2 May 2011

**PROJECT APPLICATION FOR RESIDENTIAL DEVELOPMENT
AT 132 -138 KILLEATON STREET, ST IVES**

5.0 COMMISSION'S COMMENT

SUMMARY OF PROPOSED AMENDMENTS SK01

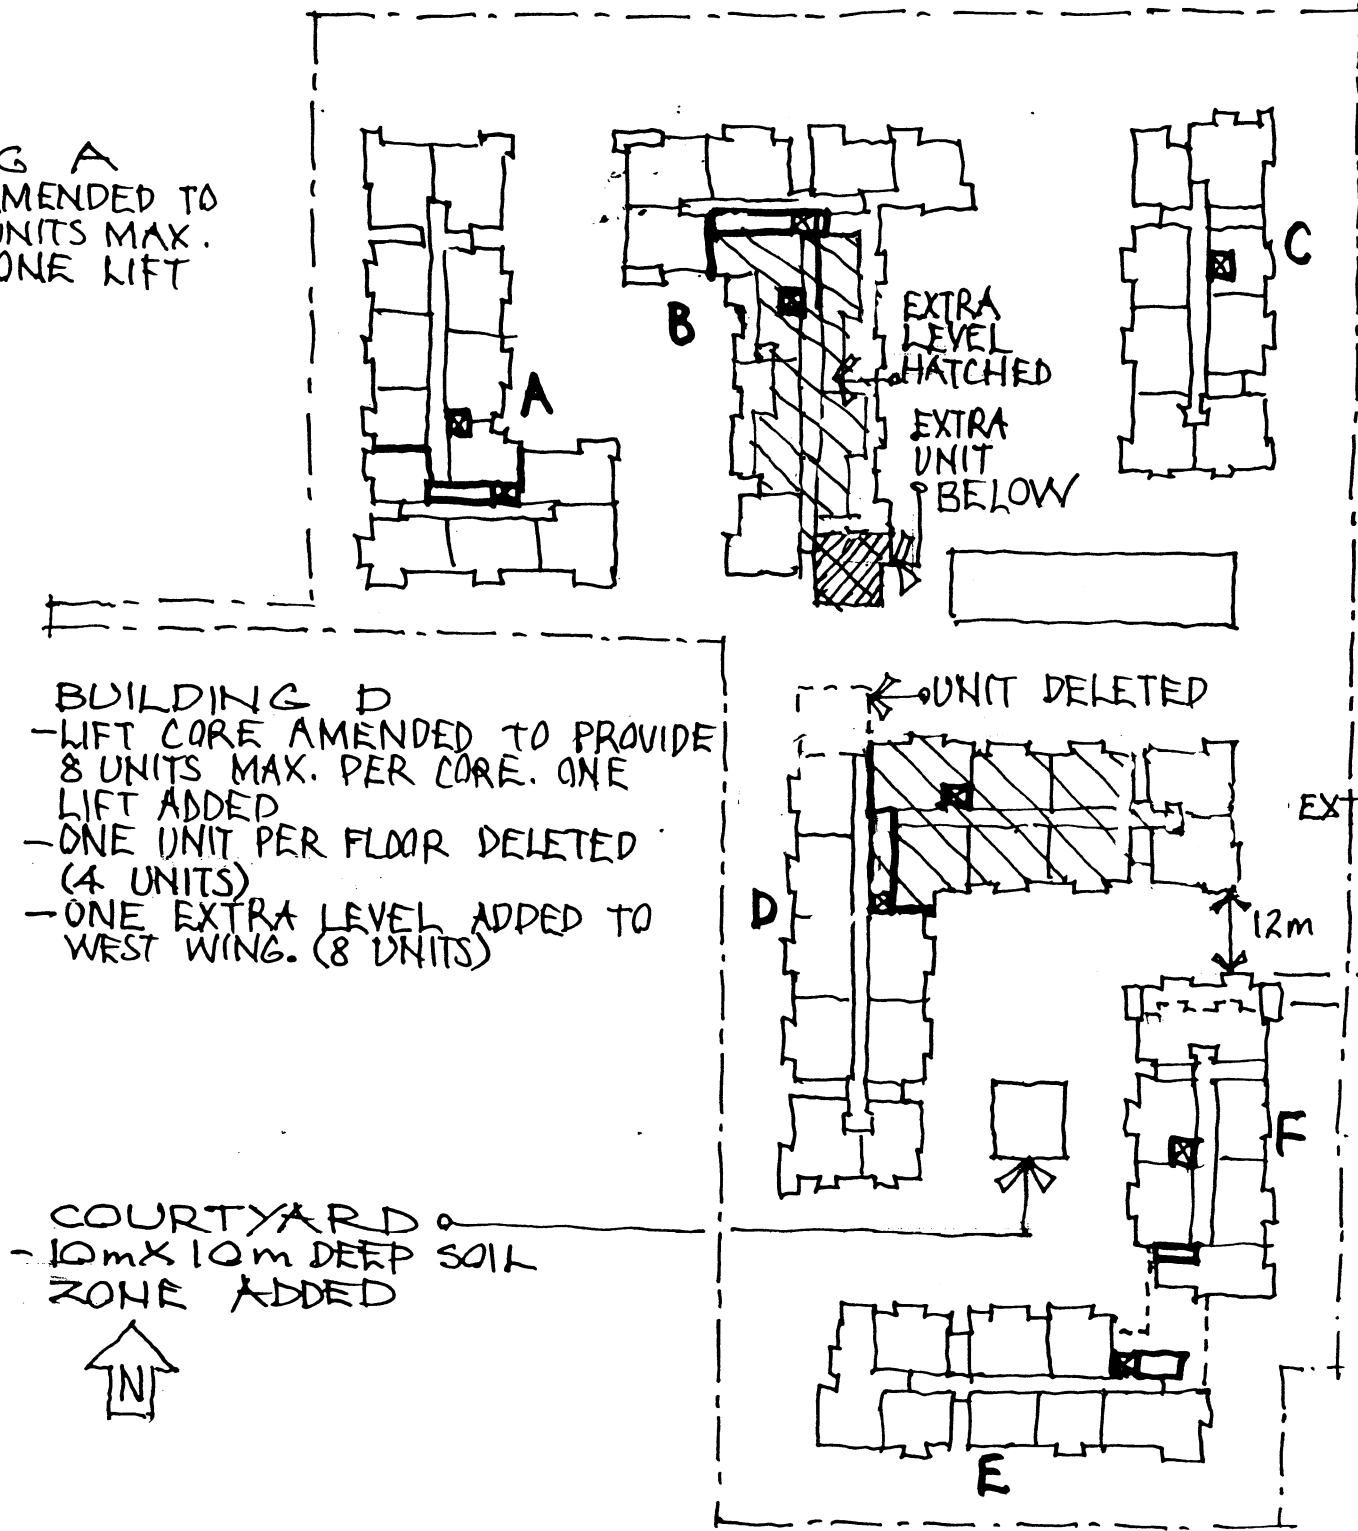
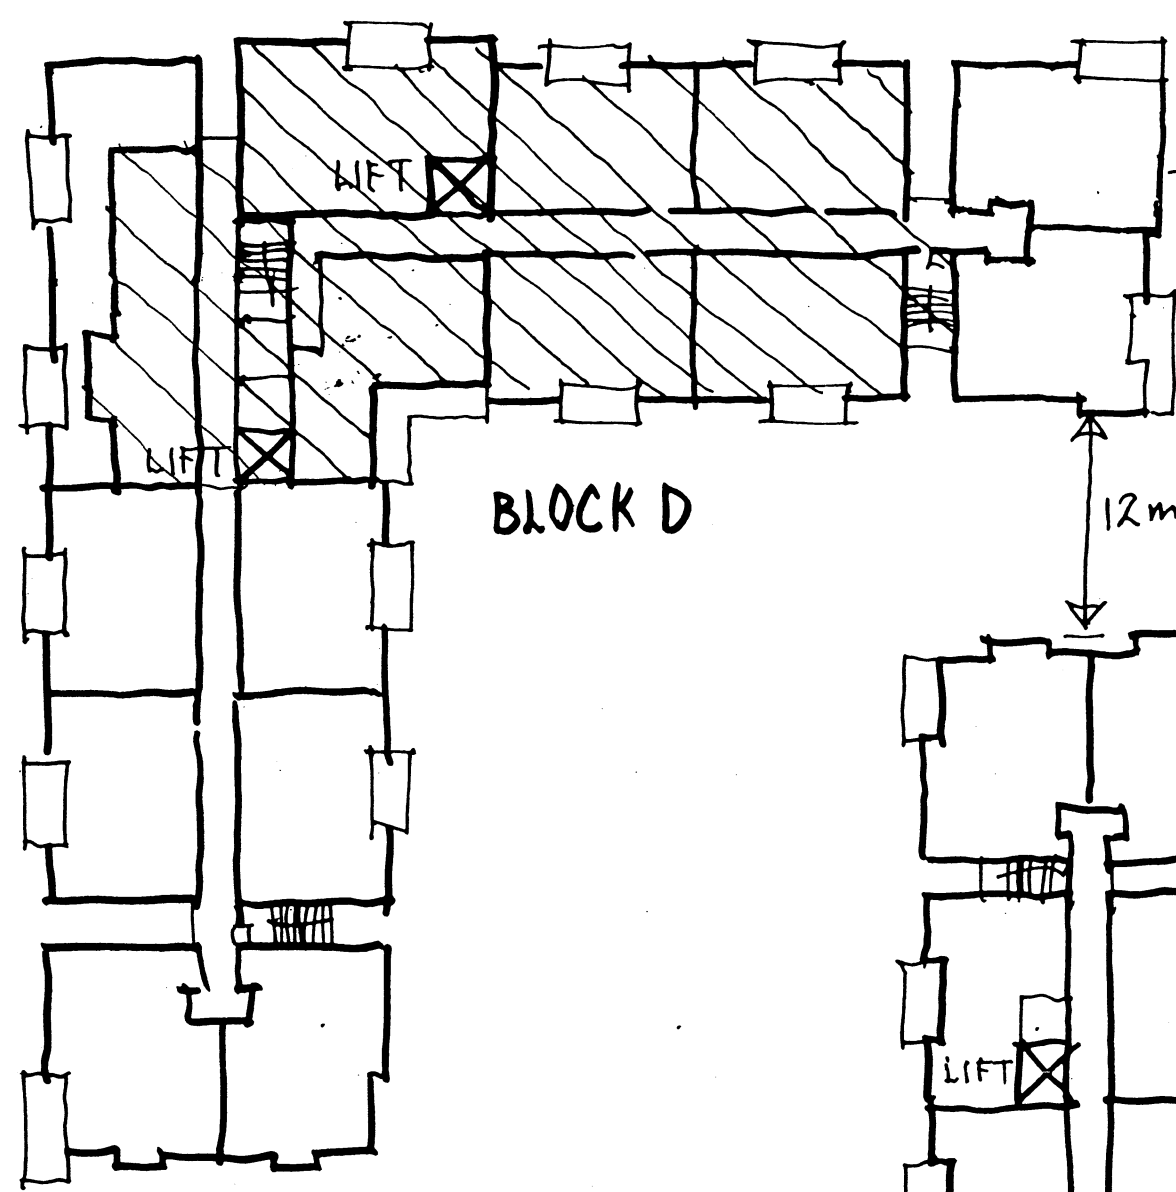
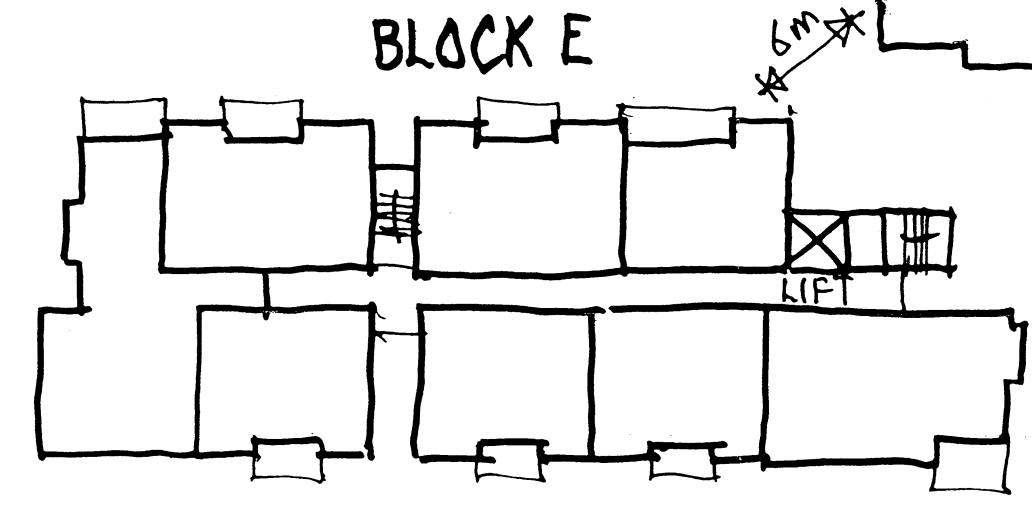
The amended proposal, as outlined in the PPR, will exceed the height control by one storey in two of the six proposed buildings, reaching a height of 19.9m in Buildings B and D. It is understood that, in addressing submissions and in order to improve the interface between the building and adjacent residences, floor space was removed from Buildings C and E (which were both reduced from five to four storeys in the PPR) and was redistributed to part of Buildings B and D.

building height in Buildings B and D. The Commission is satisfied with the Department's assessment that the additional 6th storey in Buildings B and D, being located centrally on the site, poses minimal amenity impacts as viewed from Killeaton Street as well as from the adjoining eastern boundaries. Accordingly, the Commission considers the exceedances in height in Buildings B and D to be acceptable.

The separation between Buildings E and F and Buildings D and F are non-compliant with both the RFDC and Council's DCP.

The development proposes a 5-6m setback between Buildings E and F (ground to 4th floor). The Department considers this acceptable as no windows are directly opposite each other, and no areas of private open space/balconies directly face each other between the buildings.

The development proposes a separation of 9.5m between balconies/courtyards at the eastern end of Building D and habitable rooms at the northern end of Building F at ground level. The Department considers this variation as acceptable as the ground floor courtyards are generously proportioned to allow for screening, and the actual distance between habitable rooms exceeds 12m.

The Commission considers that the site has minimal constraints and is large enough for a development to achieve the building separations required under the RFDC and Council's DCP. Despite windows and balconies not directly facing each other, it is considered a wider separation distance would still improve the amenity for residents. The Commission requires the proposal to be modified to achieve building separations required in Council's DCP. A design modification to this effect has been incorporated into the conditions of approval.
